Public comment Parke Creek Landing LLC PUD PD-24-00002 application

SITE DEVELOPMENT PLAN - PARKE CREEK LANDING  
A PORTION OF THE NW 1/4 & A PORTION OF THE SW 1/4 OF SECTION 34, T. 18 N., R. 20 E., W.M.  
KITITAS COUNTY, STATE OF WASHINGTON

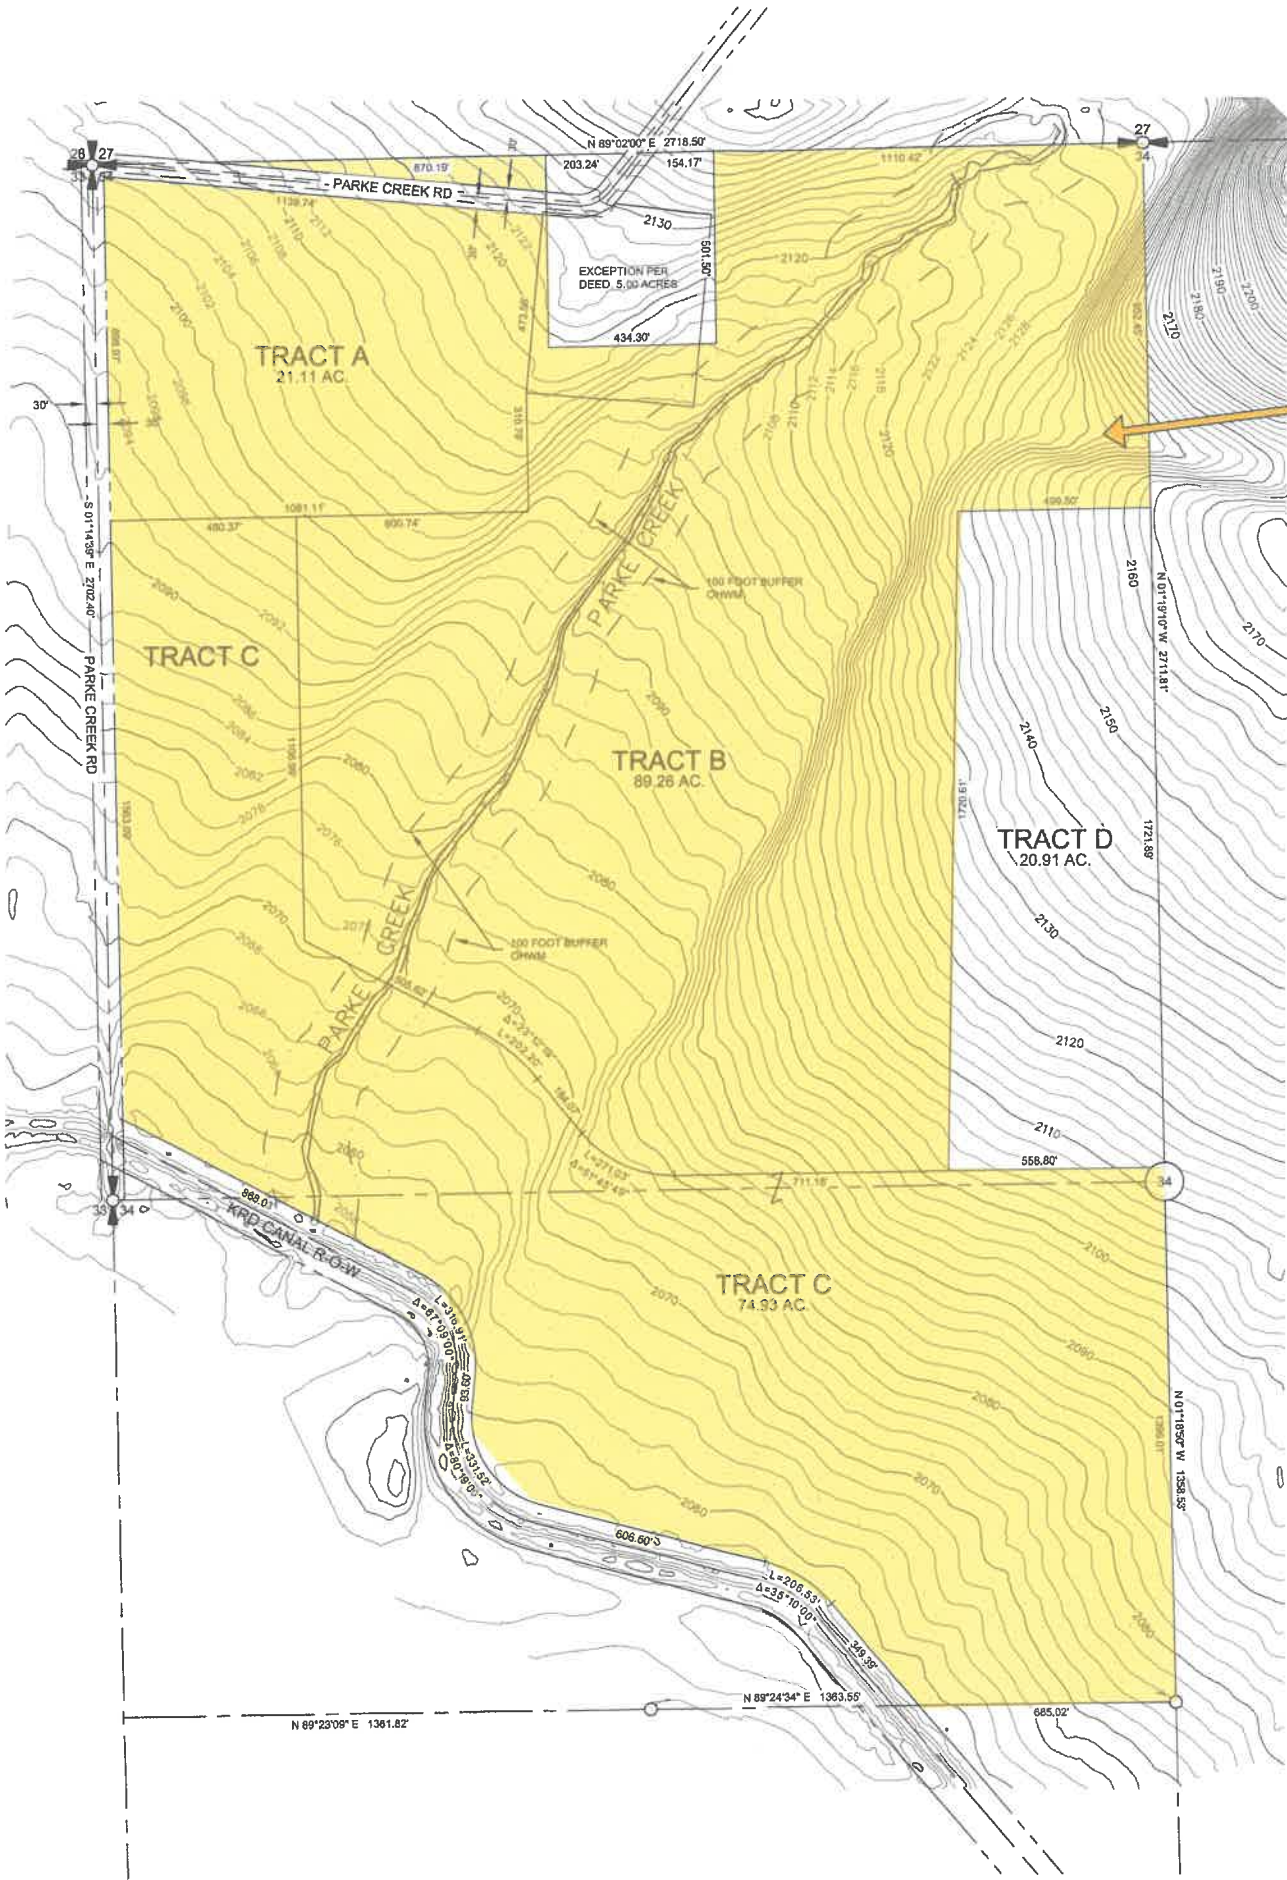
The motorsports area is really not given enough attention in this application for a residential neighborhood and the housing application lacks information for the homes and their locations on the proposed map. There is no locations set forth for the proposed domestic water system and water holding facility nor the waste water treatment areas. People will be travel via county road from this ORV park to other recreational areas close by, and our county roads will have more vehicles not supposed to travel on them. Our area is fairly quiet currently, we already have a problem of side-by-sides traveling on a 50MPH road imagine it 10X if the motorsport complex is approved.

This application seems to be a phased start of a housing project and mentions the deficit of housing in Washington state and Kittitas county but we do not feel cramming 37 homes in a small area conducive to rural living. The setbacks from the KRD are mentioned but the line drawings do not reflect this. ORV park operating 7 days a week 356 days a year from 7am-10pm with riding beginning at 8am will create significant noise if not limited to full time residents only and 2 guests. The guest number needs to have a number not just guests. We chose to live in a rural area for the peace and quiet. Homes are needed, if an ORV park is created put it in an area where restrictions can be enforced.
